**KIRKLEES METROPOLITAN COUNCIL
INVESTMENT & REGENERATION SERVICE**

Reference No: 2021/62/90103/E

Site Address: 5, Goose Hill, Heckmondwike, WF16 9EE

Description: Erection of extension to roof and erection of side dormers to form first floor accommodation

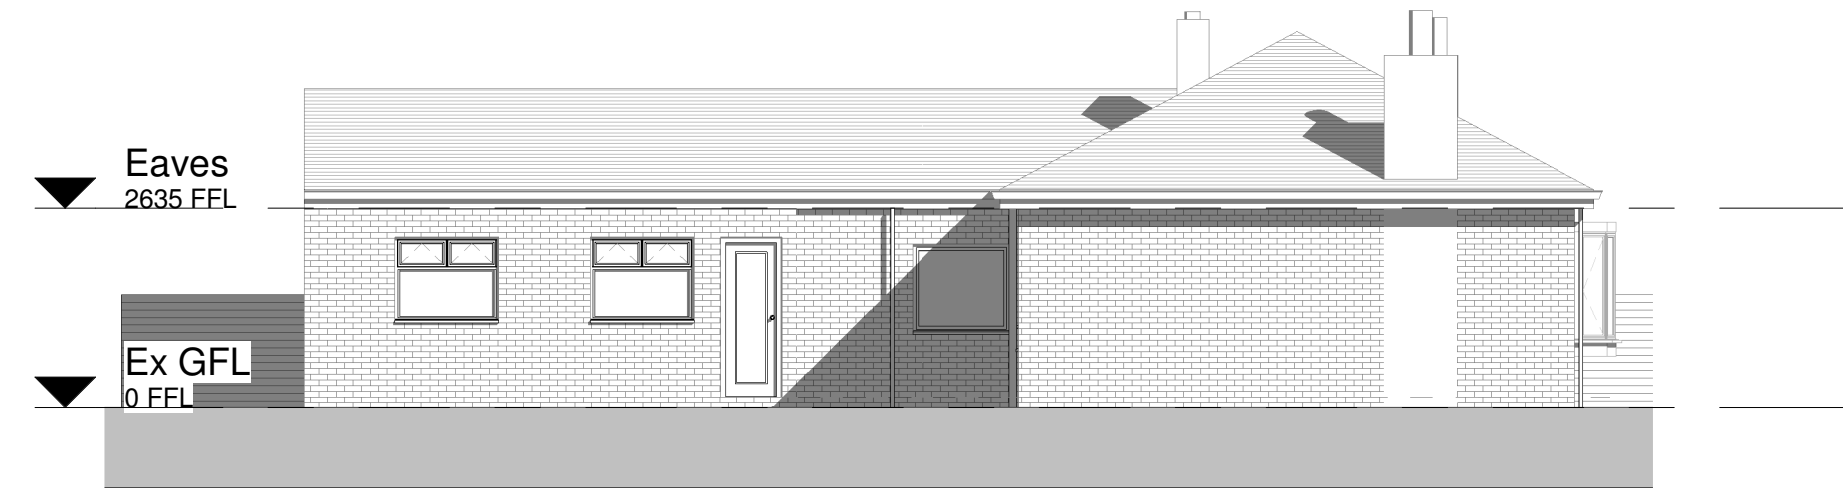
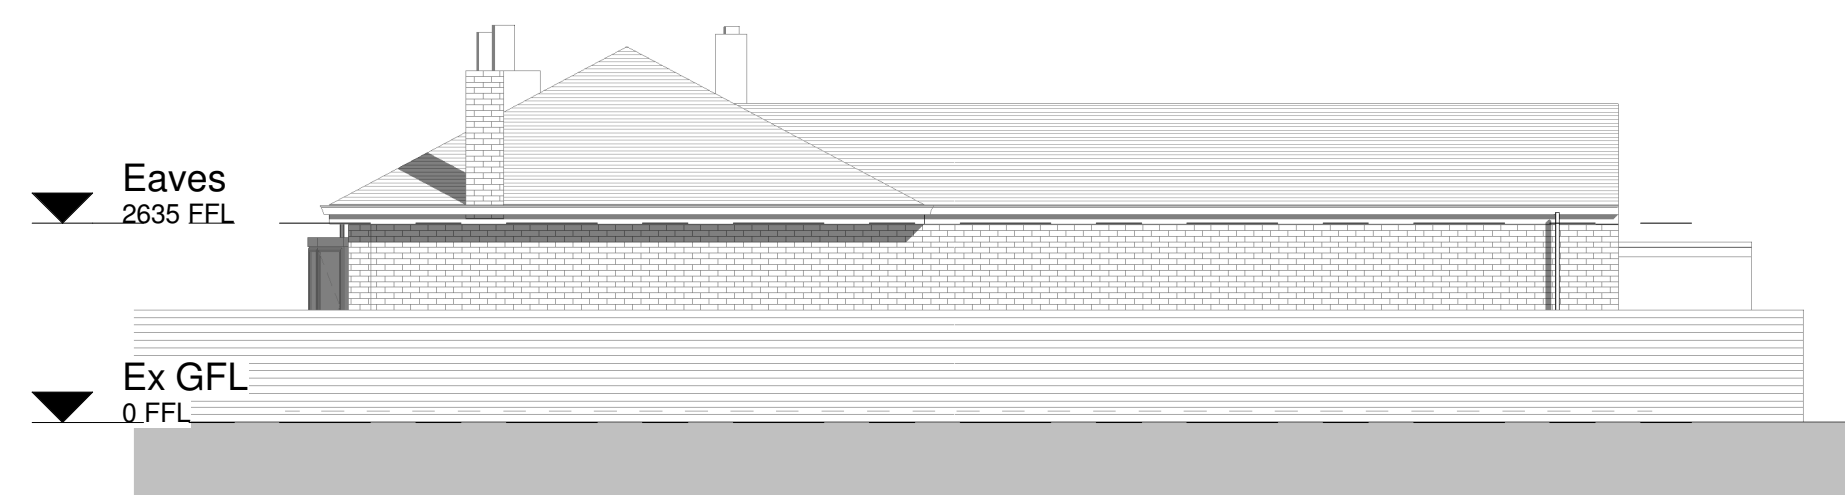
In terms of materials and details, whilst the external wall and roof materials are considered to be appropriate, the roof design is not. The original part of the bungalow has a roof with relatively shallow pitches to front and rear, and hips to either side. The current proposal would have a much more steeply pitched roof and gable ends, which would form an awkward junction, with the original part of the house, akin to a separate building attached to the rear. Parts of the south-facing gable and dormer cheeks would also be visible from the main road, behind the hipped roof and lower ridge height of the bungalow. In officers' opinion this would have a negative impact upon the street-scene and surrounding area.

Overall, it is considered that the scale and character of the proposed enlarged roof and dormers would be at odds with the design and character of the original part of the house and this would not promote good design

increase the ridge height by approximately 1.25m. This would be immediately adjacent to the mutual boundary, likely to cast more shade and have an overbearing impact. In terms of overlooking, a dormer with one small window serving a stairwell would overlook the boundary. In these circumstances, provided the window was obscurely glazed and top opening only, it would minimise impact upon residential amenity of this element of the design.

1. The design of the proposed roof enlargement, with a steeply pitched roof, gable ends, dormers to either side and ridge height, which would be higher than host dwellinghouse, would be disproportionately large in relation to the existing ground floor extension and at odds with the design of the original part of the house. It would also form an awkward attachment to the host dwellinghouse, which would be an incongruous feature within the street-scene. This would not promote good design and is contrary to policy LP24 of the Kirklees Local Plan, the aims of chapter 12 of the National Planning Policy Framework, and the recently adopted House extensions Supplementary Planning Guidance.

2. The height and massing of the proposed roof extension and dormers would have an overshadowing and overbearing impact upon the residential amenities of the occupants of the neighbouring property to the east, at 7 Goose Hill. This would not promote good design and is contrary to policy LP24 of the Kirklees Local Plan, the aims of chapter 12 of the National Planning Policy Framework and the recently adopted House extensions Supplementary Planning Guidance.
